DECISION DELEGATED TO DEVELOPMENT MANAGER

Application No: H13-0847-20 **Applicant:** Mr J Hook
Proposal: Erection of 2 detached dwellings
Location: Rear Of 46 Seas End Road Moulton Seas End Spalding
Terminal Date: 24th December 2020

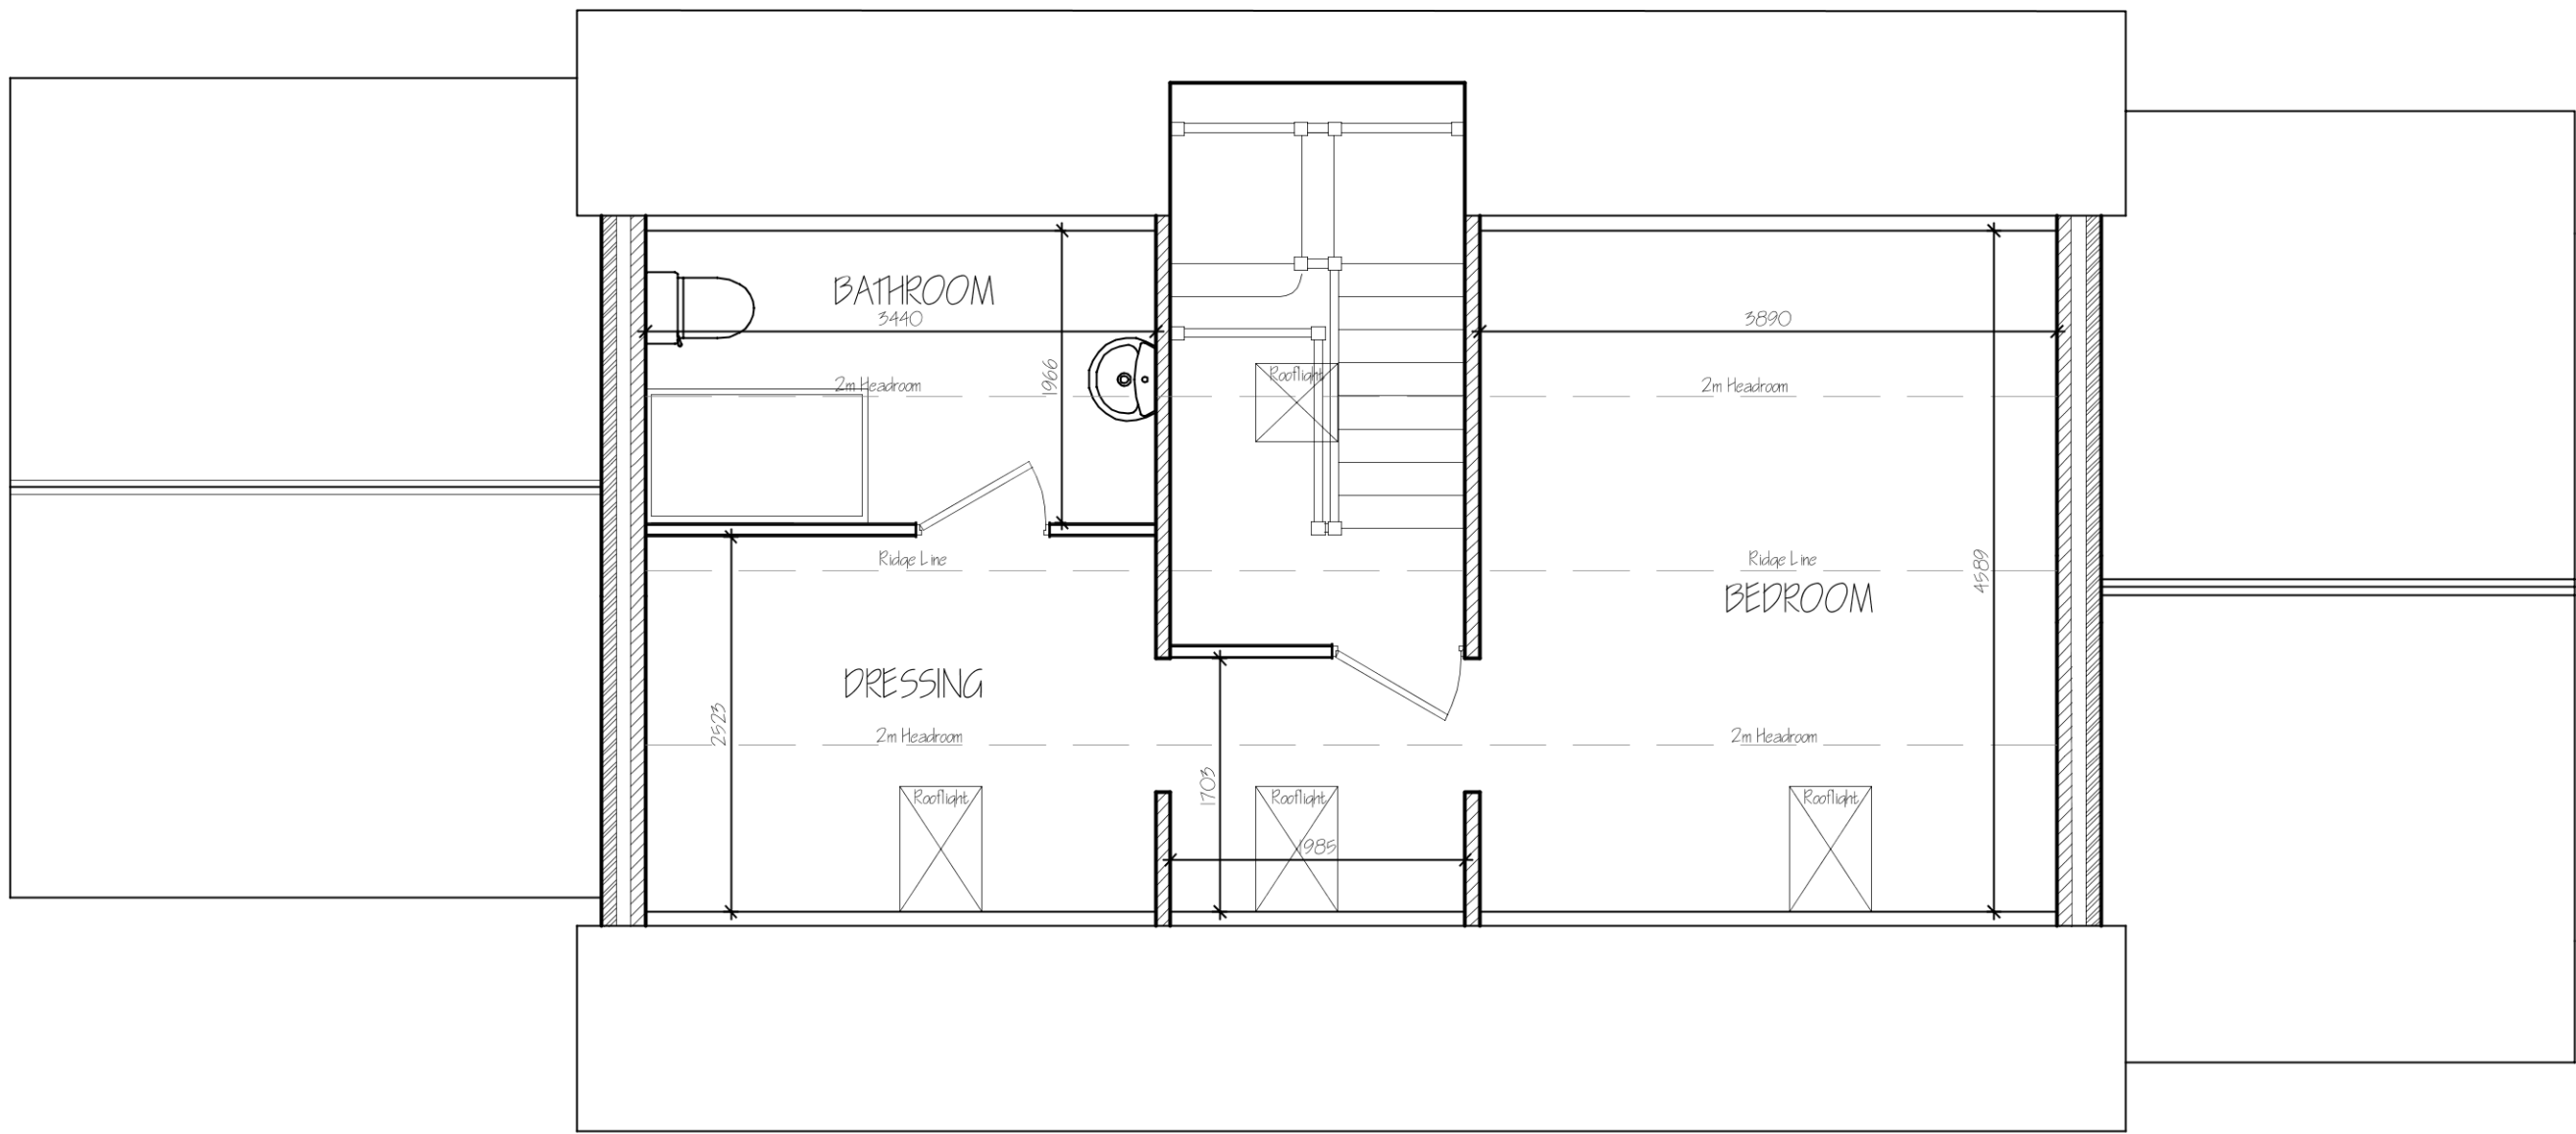
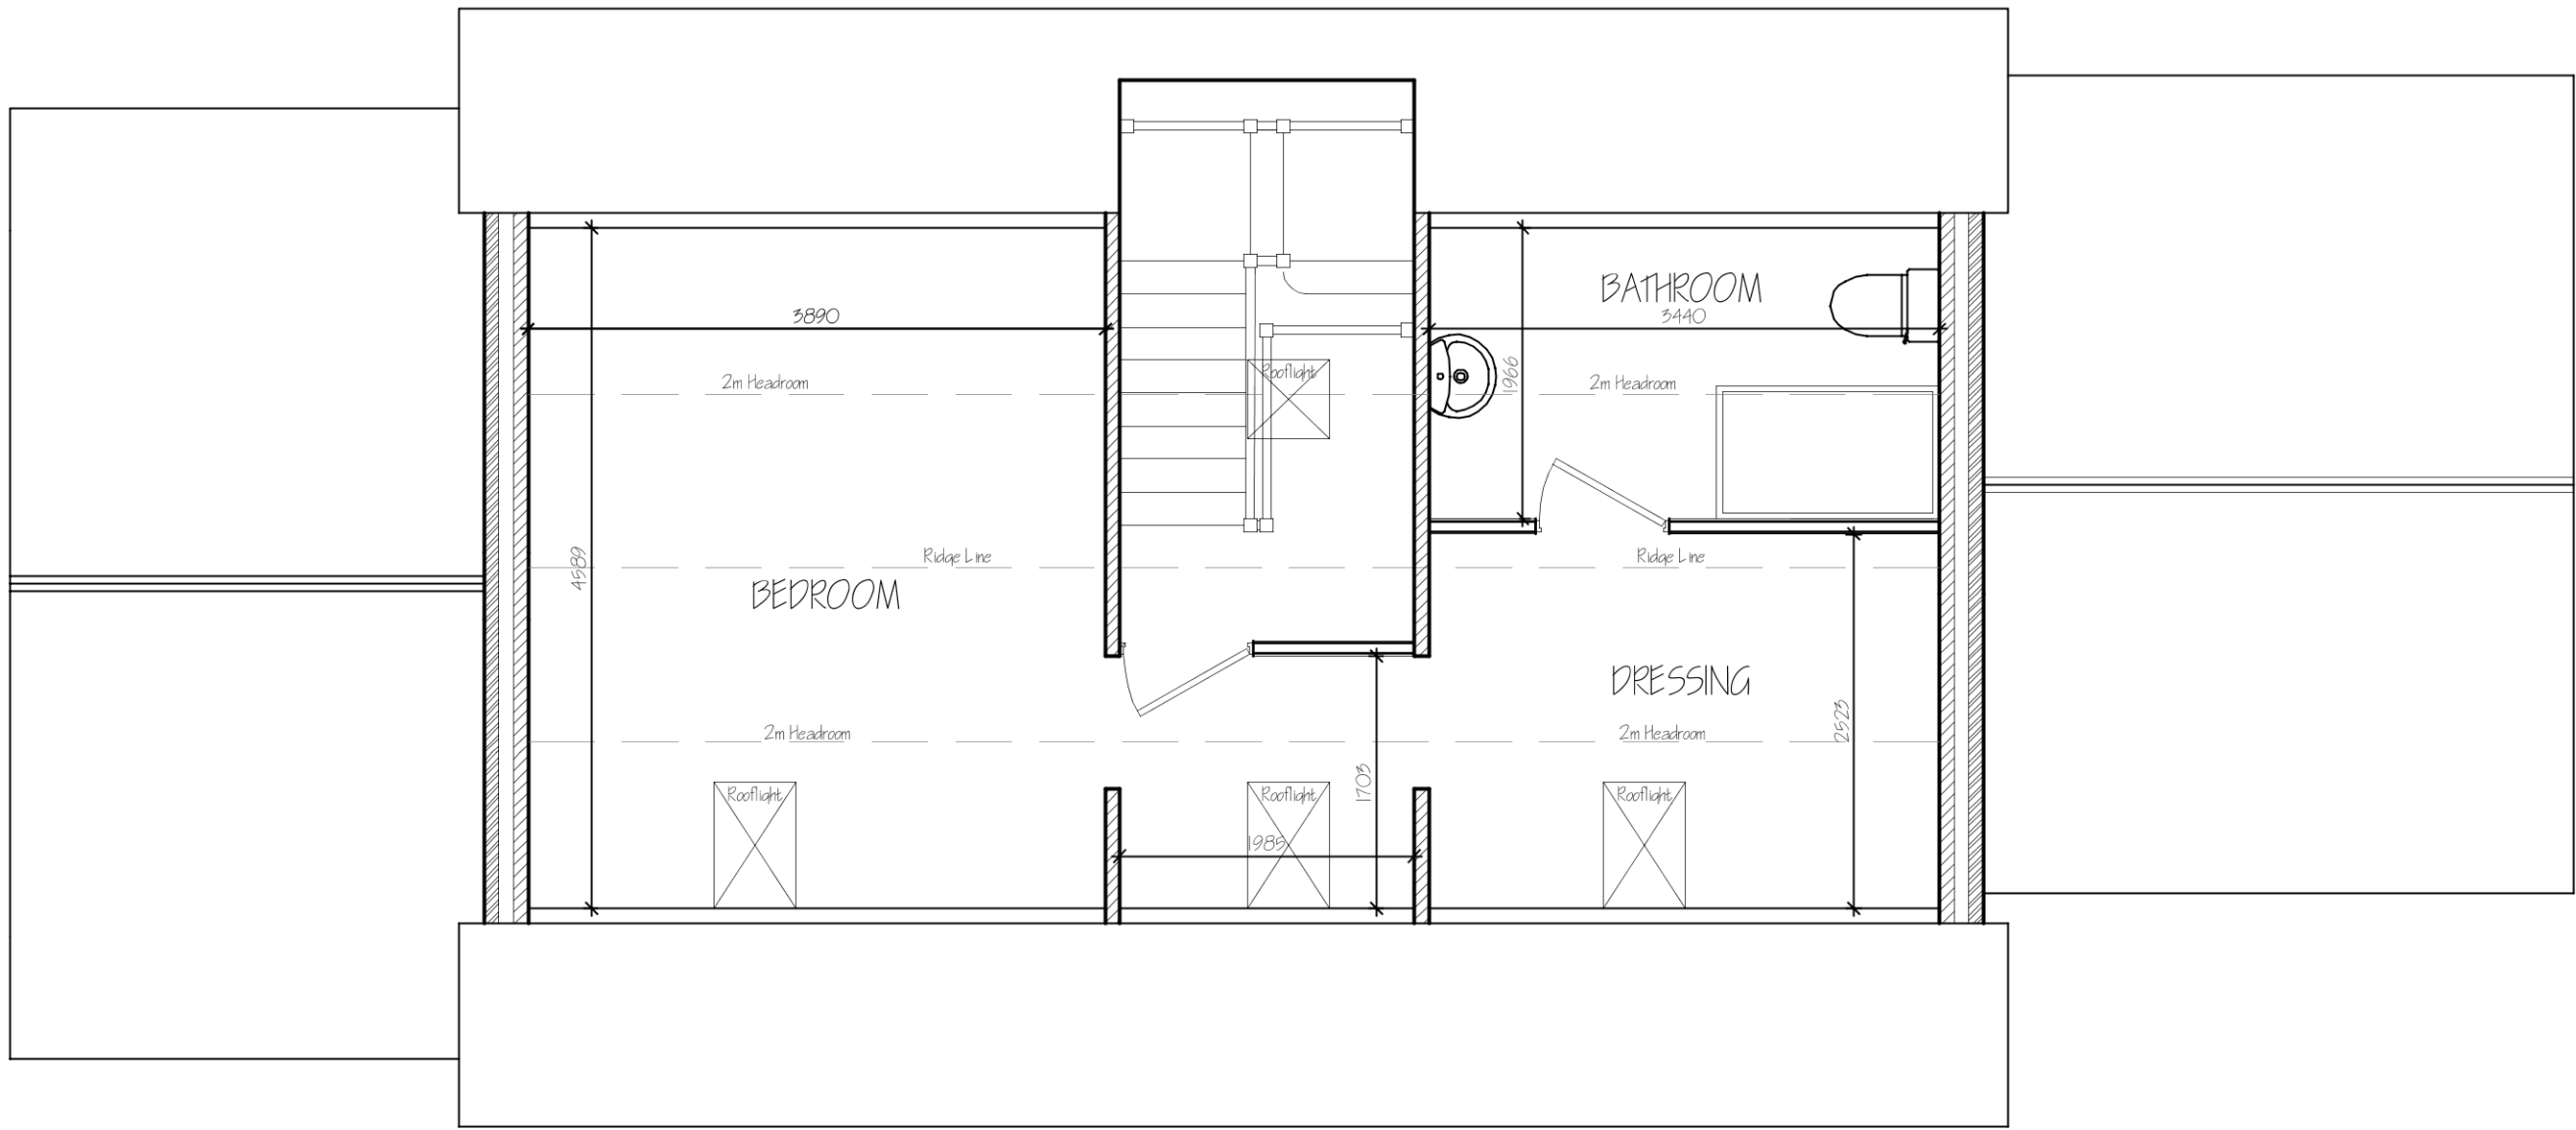
Both dwellings would have rooms in the roofspace. However, the plans have been revised in order that the only window on the rear facing roof slopes would be above the stairs. There should therefore be no detrimental overlooking of existing properties to the north or south of the site. Furthermore, there are no openings proposed on the eastern elevation of Plot 2 so there would be no overlooking aspect in that direction either. The side facing windows/doors to the lounges of the dwellings would be at such an angle that any views towards the rear windows of no. 8 Hall Lane would be extremely limited and also the dwelling to the north-west of Plot 1 is single-storey.

Plots 1 and 2 are offset from one another meaning that an appropriate level of privacy will be afforded between ground floor windows. However, the rooflights at first floor to Plot 2 would face towards the lounge window of Plot 1 as well as its garden. There would therefore be an overlooking impact in this regard.
